From: Tim Screen
Sent: 24 July 2023 17:25
To: Thomas Webster
Subject: 23/017111/REM - Land North Of Bicester Avenue Garden Centre, Oxford Road, Bicester
Attachments: Substation Landscape Proposal.pdf

The larger areas of scrub planting (southern and eastern areas) and wildflower meadow should have 'pioneer' *Betula pendula* and *Alnus glutinosa* trees to provide better visual mitigation and wildlife habitat (refer to amended drawing enclosed) – tree locations to be indicated on a detailed landscape proposals. However the narrow verge (road access) where maintenance vehicle access drivers will be compromised by overhanging vegetation, unless the narrow verge can be widened with onsite planting outside the application boundary: *Prunus spinosa* requires space because once it establishes it will sucker and spread.

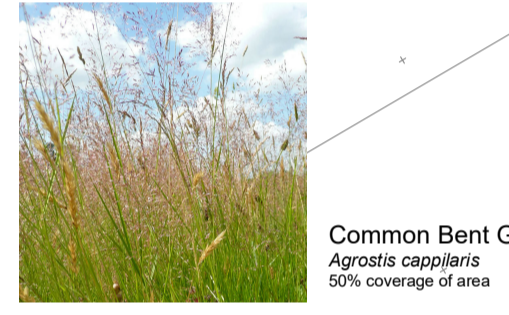
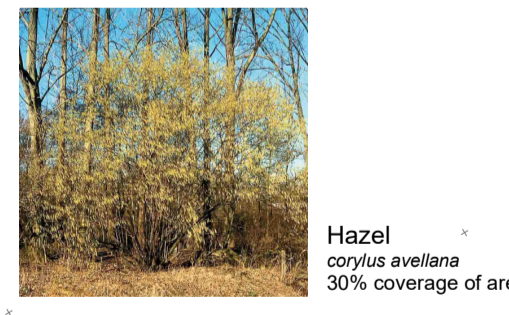
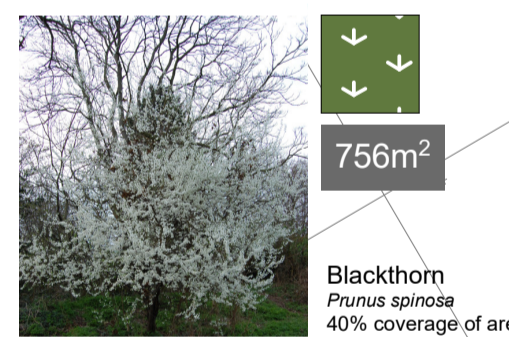
More detail on the landscape proposals required:

1. A planting schedule is required to indicate the Latin names of native trees and shrubs, their sizes, root condition and numbers.
2. Existing trees on or adjacent to site are to be retained shall be protected in accordance with BS 5837:2012 Trees in relation to design, demolition and construction. Recommendations from commencement to completion of all works on site.

3. All excavated areas to be backfilled with subsoil to BS 8601:2013 Specification for subsoil and requirements for use (imported subsoil to be laid on site's existing subsoil profiles) and overlaid with topsoil to BS 3882:2015 Specification for topsoil BS 3882 – General purpose grade. All topsoiled areas to be clear of rocks and rubble larger than 50mm diameter and any other debris that may interfere with the establishment of plants. Shrub areas to have a minimum depth of 400 mm topsoil. Tree pit soil depth/volume in accordance with BS 8545:2014 Trees: from nursery to independence in the landscape. Recommendations.

4. The Emorsgate Mixture EM 1Mix to be implemented in accordance with Emorsgate's instructions.
5. All plants are to be supplied in accordance with Horticultural Trade Association's National Plant Specification and from a HTA certified nursery. Delivery and backfilling of all plant material to be in accordance with BS4428/JCLI/CPSE Code of Practice for 'Handling and Establishing Landscape Plants, Parts I, II and III.

6. All trees to be supplied planted in accordance with BS 8545:2014
7. Native shrubs are to be planted in their species groups of 7,9 and 15 in an irregular pattern.

8. All plants shall be watered to field capacity immediately after planting and mulched with 50mm depth of medium grade crushed mulch.
9. All trees to be double-staked with cross bar and wedged, using 1.5 m long, 75 mm diameter rounded tree stakes 75mm brace, rubber wedge and spacer block. Stakes not to extend more than 650mm above ground level.

10. Root barriers (ReRoot 1000 or equivalent) to be included adjacent to structures, cabling and services, where necessary.
11. Unless otherwise stated planting shall be carried out during the period of 1 November to 31 March when the ground is not frozen, or waterlogged.
